AA TAKLA ENGINEERING, PLLC

Project: Providence Creek Amenity
Location: Center & Pool, Fuquay-Varina
Date: 6/25/24
Company: Poythress
Care Of: Juan

Sketch #2

ROOF FRAMING PLAN

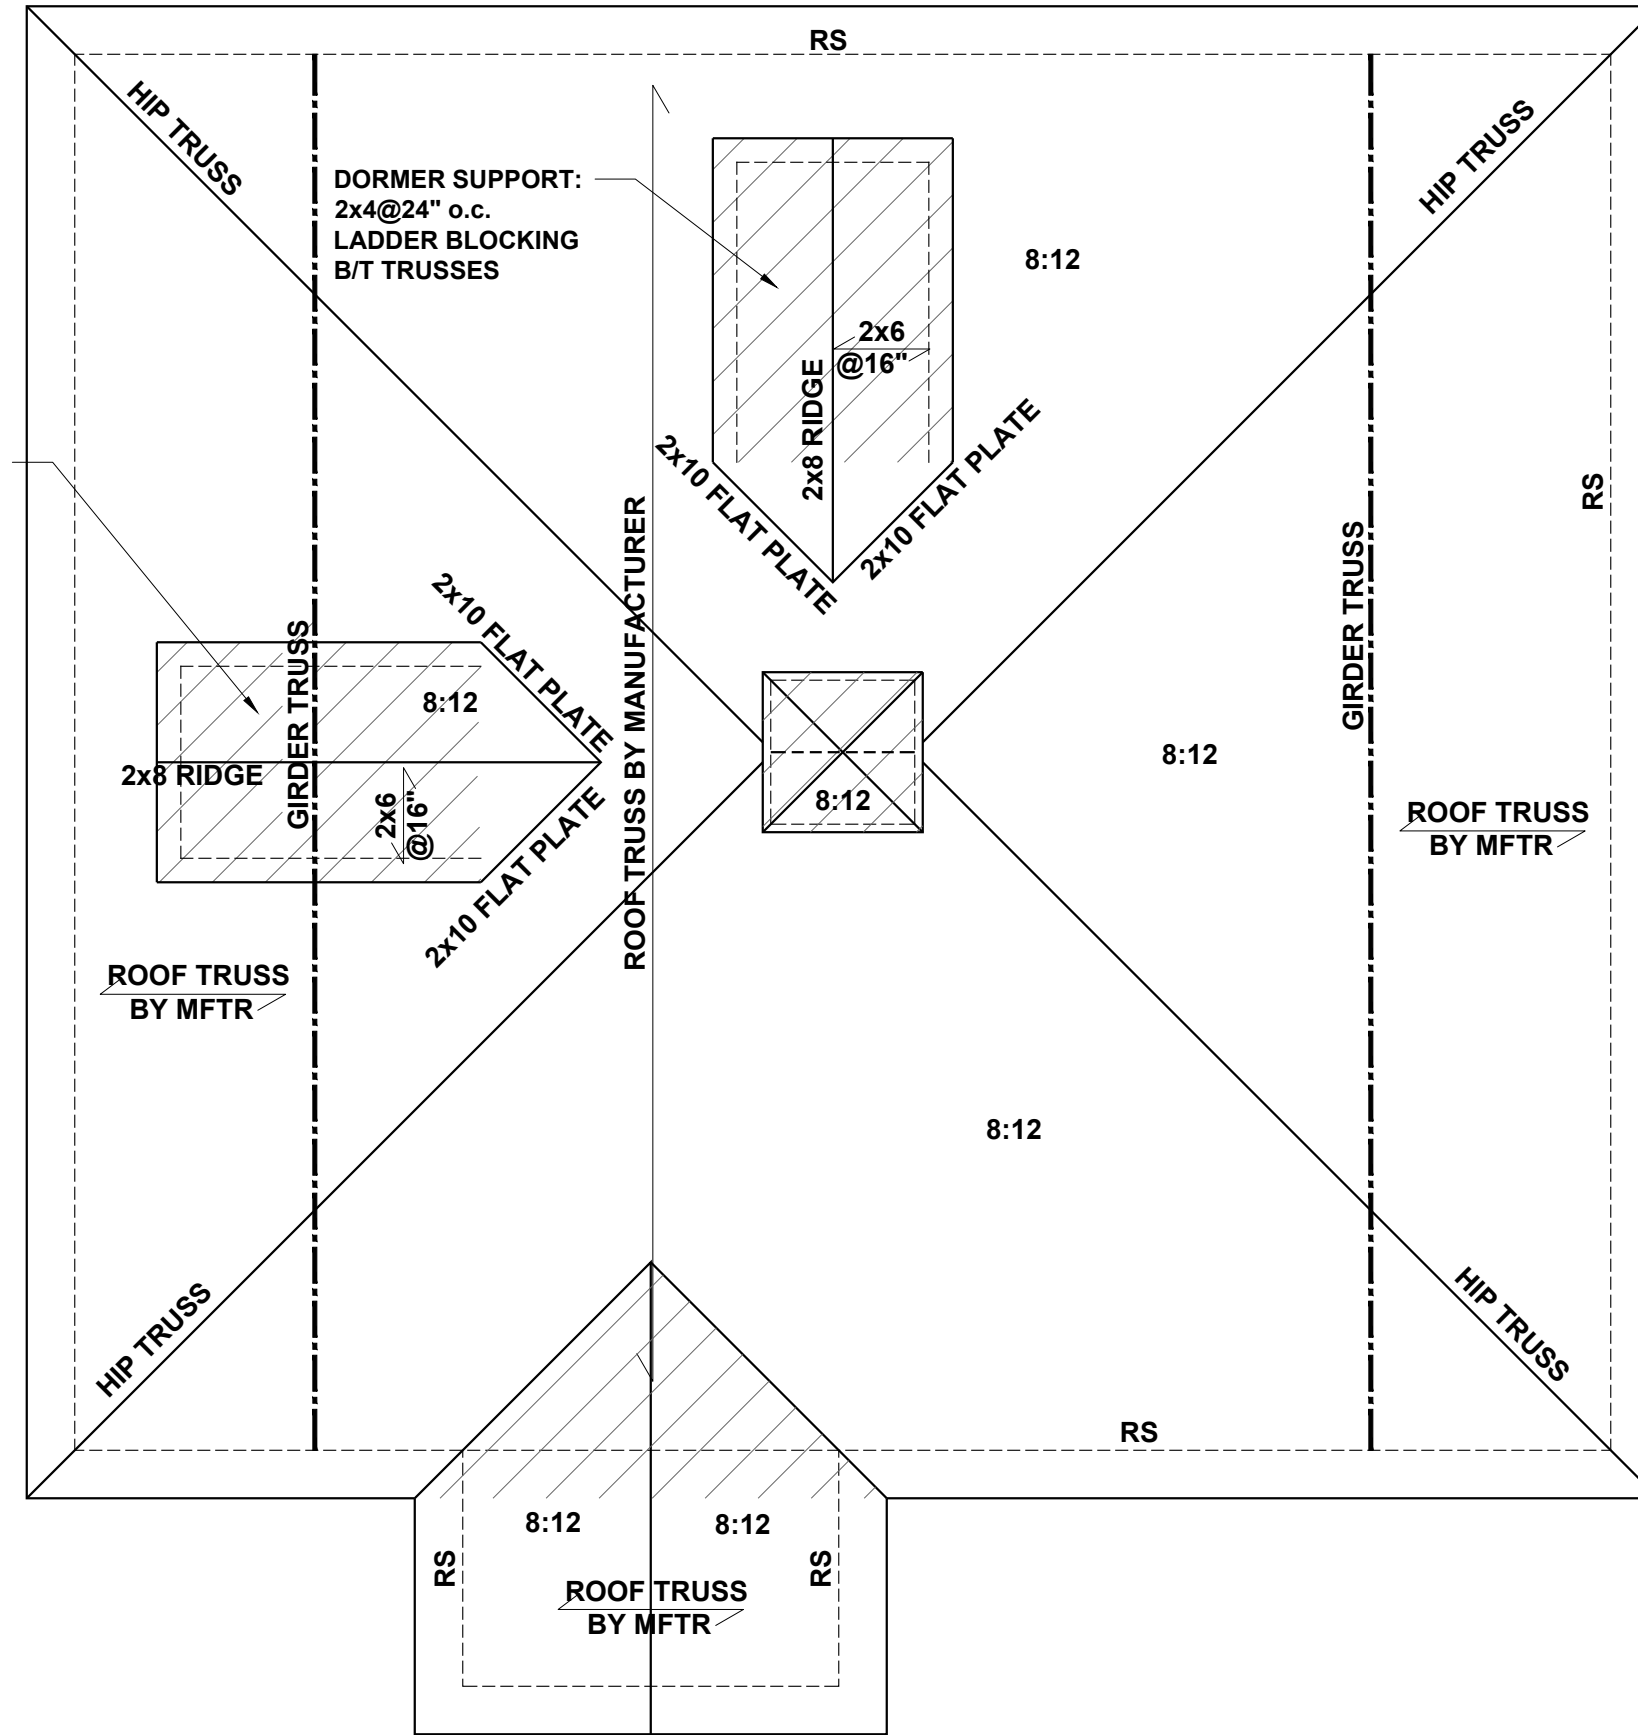
no need for the strap
Existing uplift connection is adequate
